From: mark gibbens [REDACTED]
Sent: 27 September 2019 17:01
To: Sian Eggington
Subject: Re: FW: Further Information Required on Your Ref: PP-08163331 Our Ref: M/82/19/HH
Attachments: We sent you safe versions of your files; 6 Main Drive - Block Plan - REV B - 27.09.2019.pdf
Categories: Green Category

Block Plan - 1:500

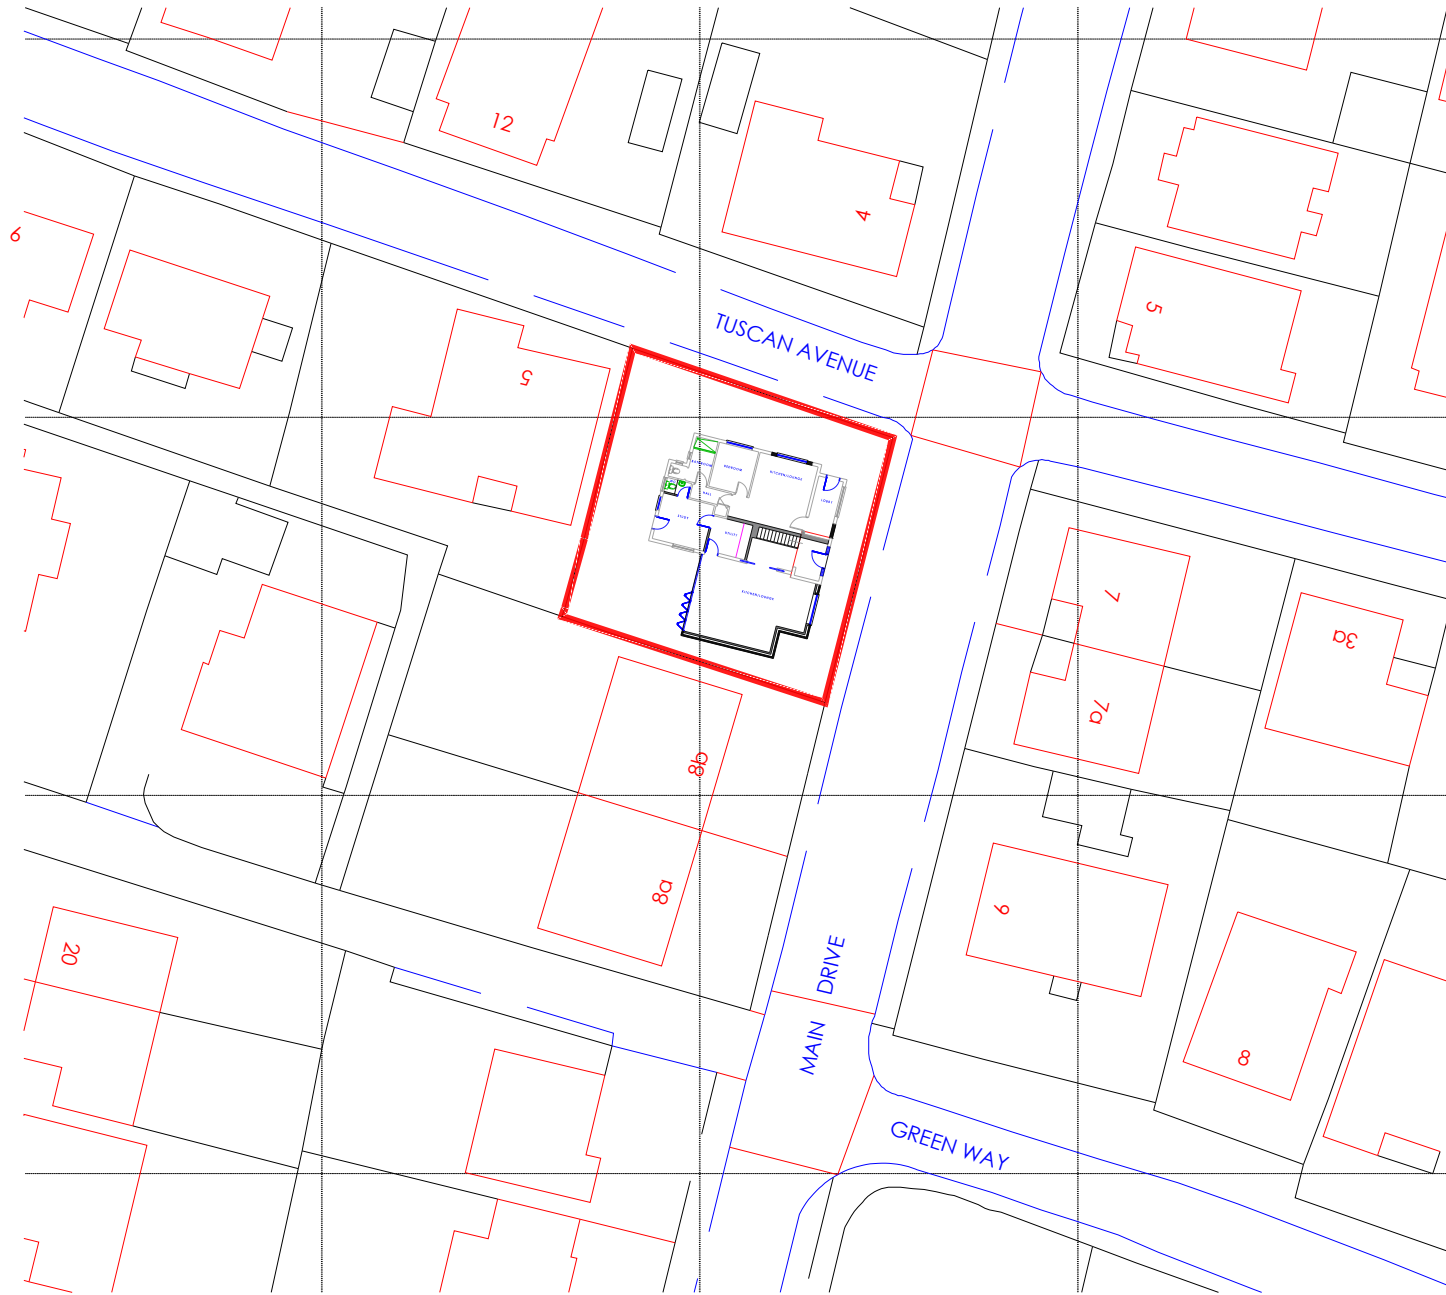
Thank you for your email, in regards to the plan you are required to only have a red outline around the site on both the location and block, please remove all other red outlines on the plan. The proposed extension should also be clear on the block plan at present half the house is dots, a simple outline of the house would be sufficient (like the original) but with the proposed extension shown with dimensions on the block plan to the site boundaries. The dimensions you have provided are sufficient however the rest of the plan is not.

Apologies for that! How's this - see attached.
